Please find attached Nemo Link Limited's written submission for Deadline 1 in respect of the examination of the Thanet Extension Offshore Wind Farm.

**THANET EXTENSION OFFSHORE WIND FARM (THE PROJECT)****DEADLINE 1 – 15 JANUARY 2019****NEMO LINK LIMITED****WRITTEN REPRESENTATION****RESPONSE TO EXAMINING AUTHORITY'S (EXA) FIRST ROUND OF WRITTEN QUESTIONS****1. INTRODUCTION**

Access Plan -
Sheet 1 of 2

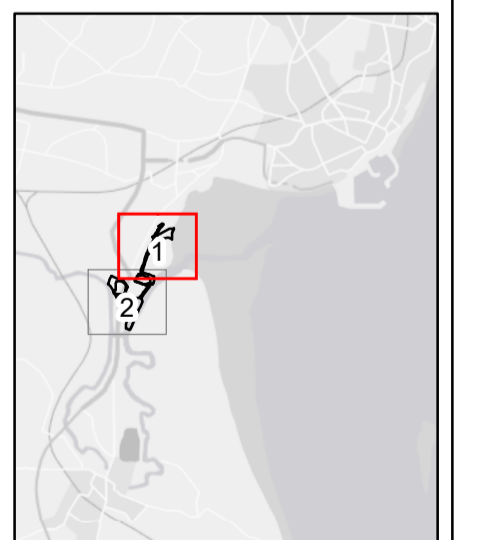
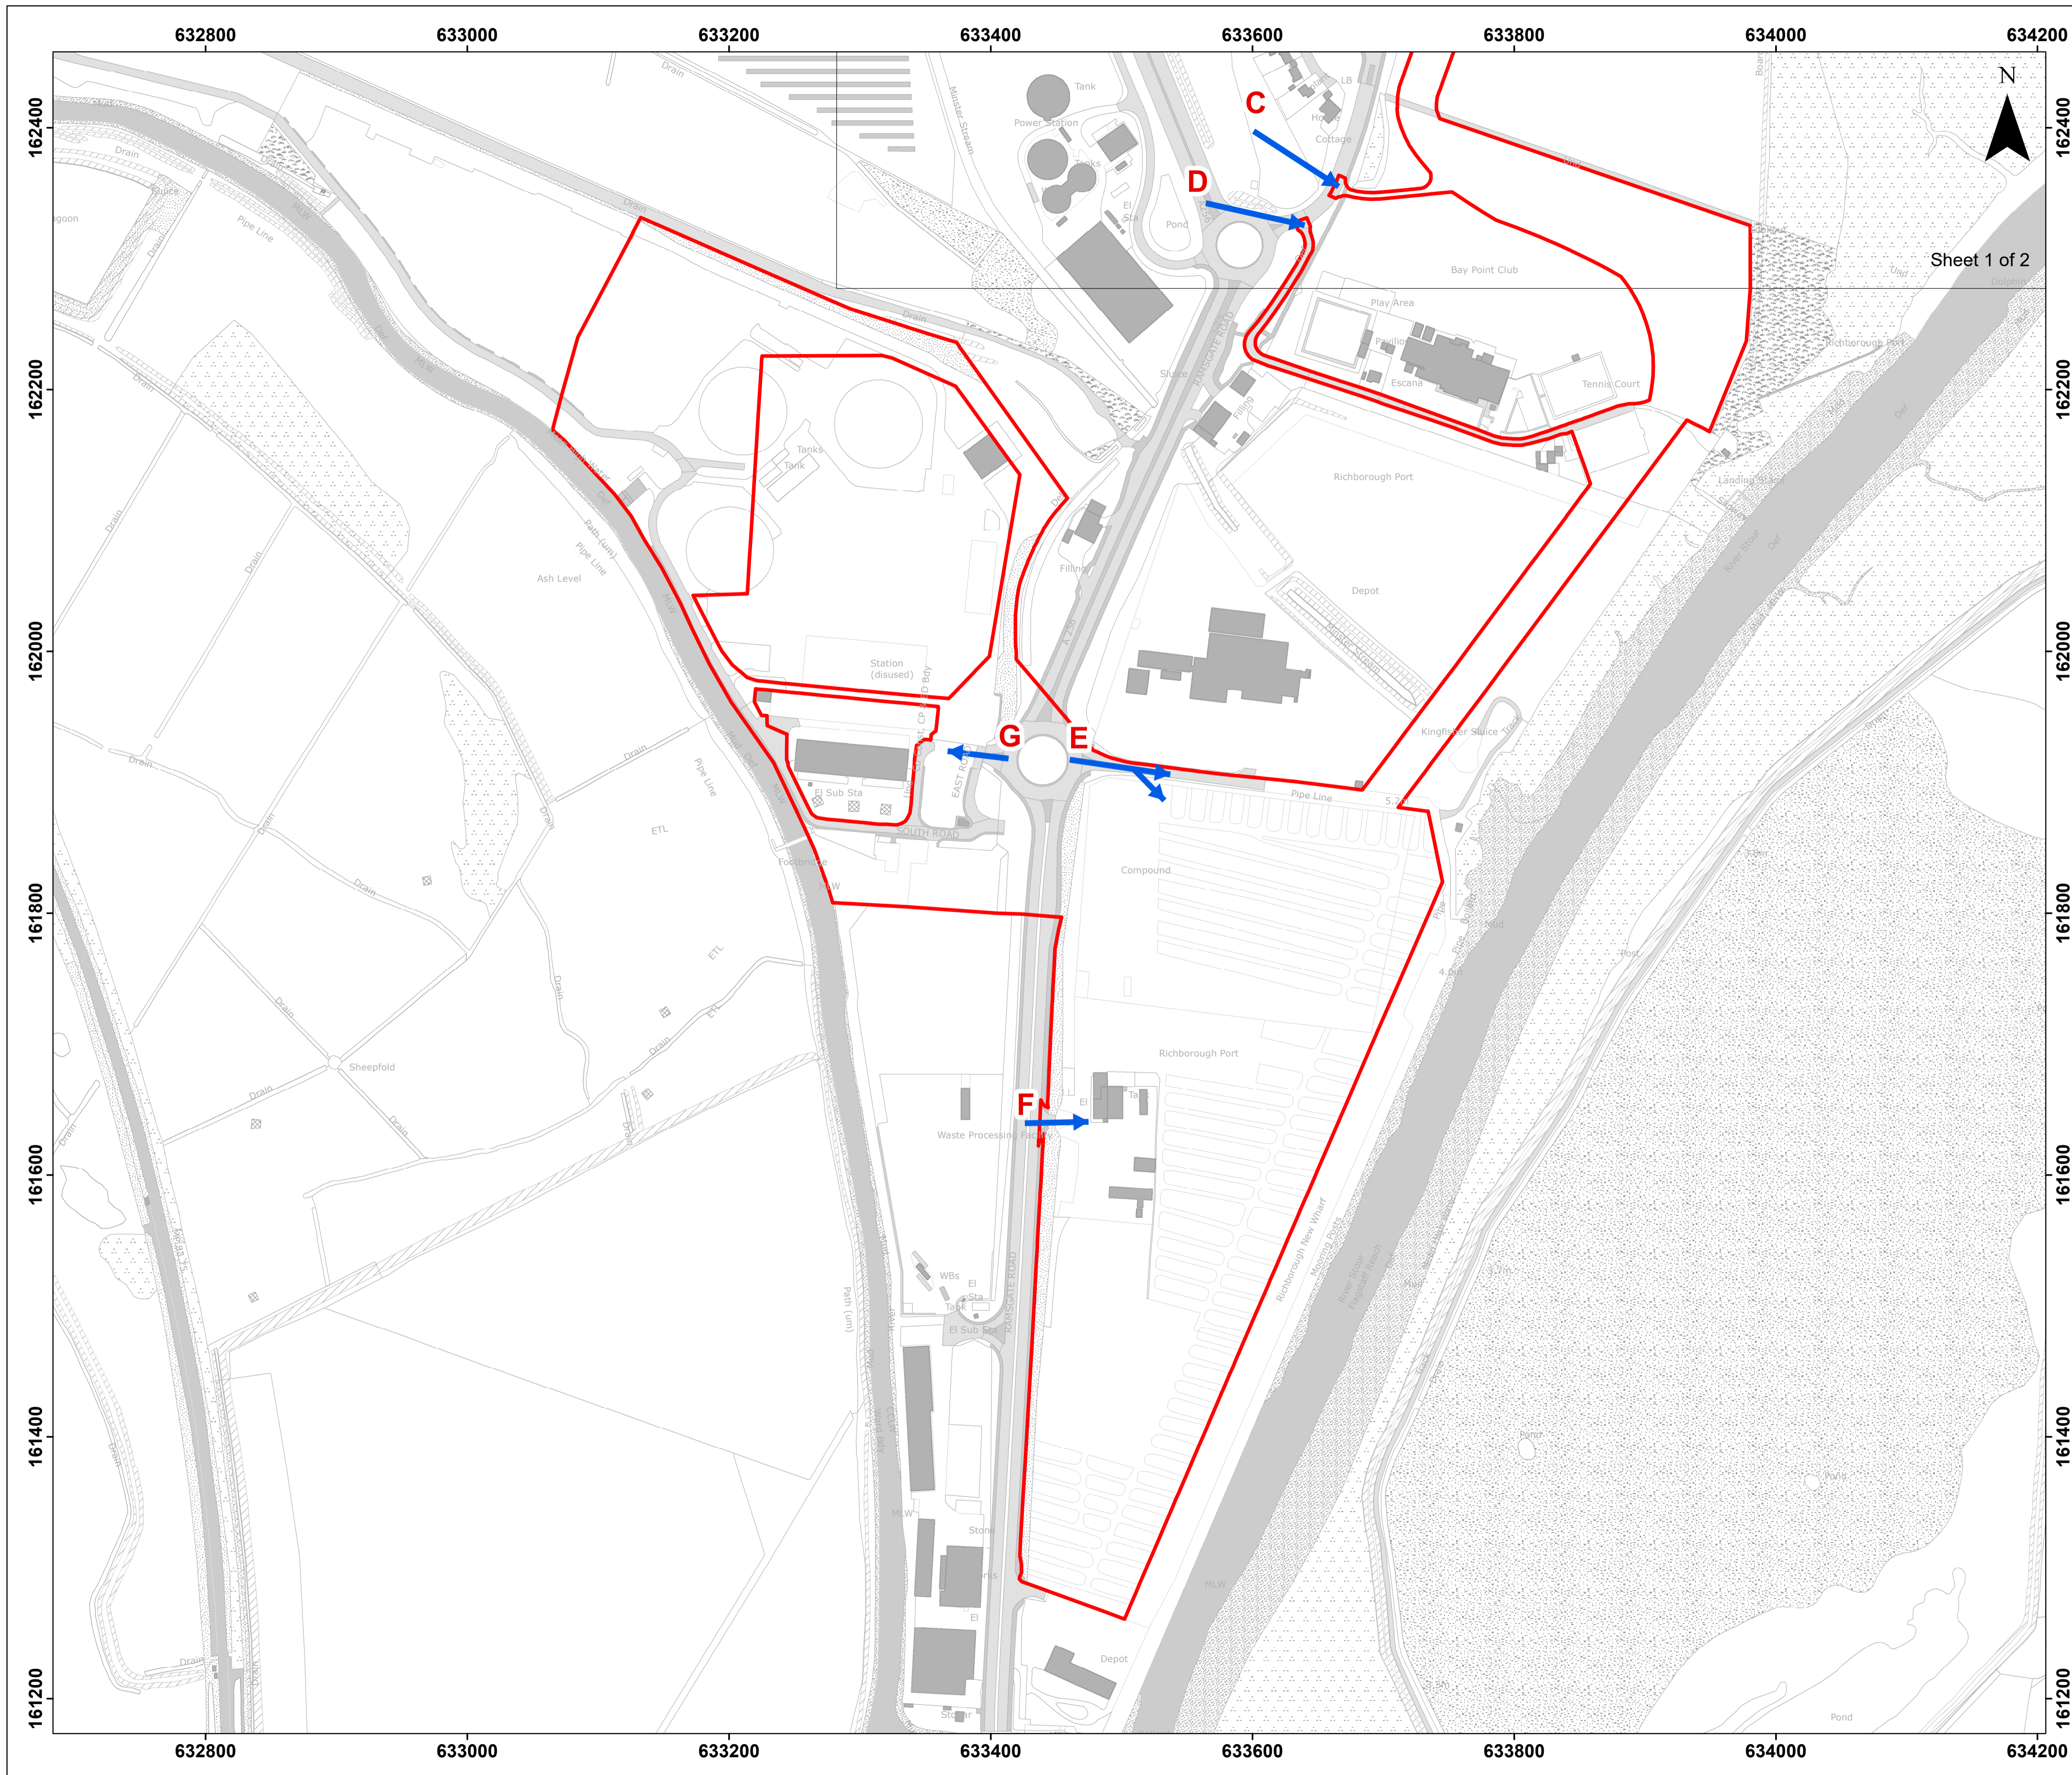
- 7.1 The Project seeks the upgrading and widening of an existing access from Sandwich Road and more importantly the crossing of the surface laid Nemo cables by vehicles to access Work No 4A, 4, 3B. The surface laid Nemo cables were not constructed with the intention of heavy construction traffic crossing them. No details have been provided to demonstrate how the construction traffic will cross the existing chalk bund where Nemo's cables are surface laid. Therefore, NLL objects to the inclusion of this work.

- 7.2 NLL has not been provided with technical details as to how this access track would be constructed, or sufficient details to demonstrate that it would not adversely interfere with the Nemo cable.

- 7.3 NLL's preferred technical solution would be one that completely avoids the surface laid Nemo cables, for example by the delivery of a bridged solution that does not involve the crossing of the surface laid Nemo cables by construction traffic.

Figure 1.15: Inland TJBs in cross-section (over ground)

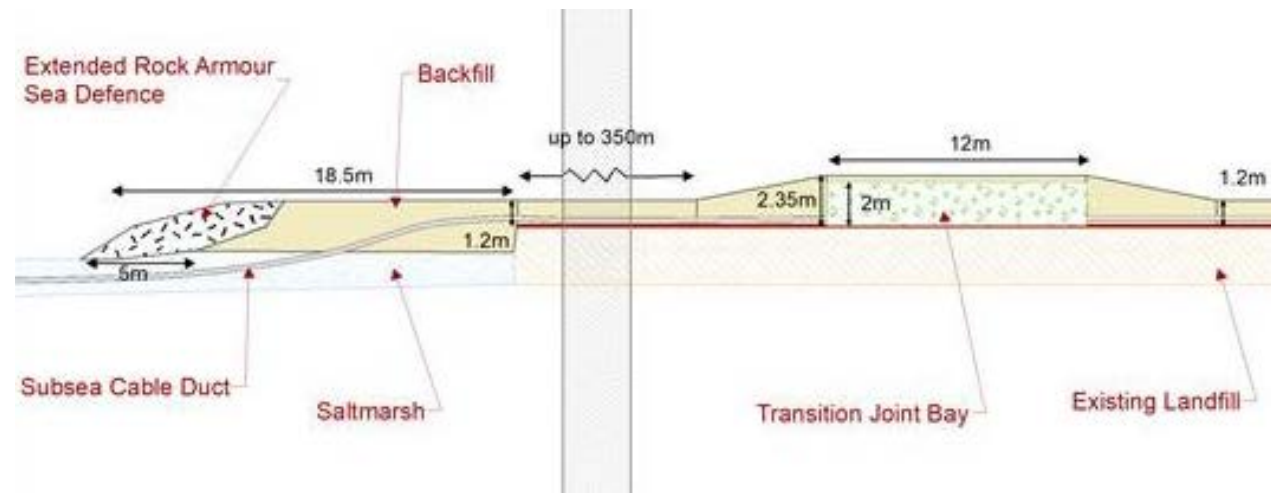
- 6.3 NLL does not understand the broader implications for the seawall, for example whether the effect of diverting seawater to the north by the construction of a seawall would be to adversely affect the integrity of the Nemo cable to the north.

- 6.4 Given that the Applicant has included an alternative works package in Work No. 3B(a), NLL's position is that the DCO should only authorise Work No. 3B(a) and that the DCO should not authorise Work No. 3B(b) and Work No. 3B(c). It is not clear why the Applicant requires three options.

- 6.7 NLL understands that the Applicant intends to amend the dDCO to remove any ability to extend the seawall. NLL supports this amendment, as it resolves one of NLL's concerns in respect of the interrelationship between Nemo and the Project. NLL reserves its position to make further submissions on this issue at Deadline 2 in the event that the Applicant does not remove the ability to surface lay its onshore export cables from the dDCO.
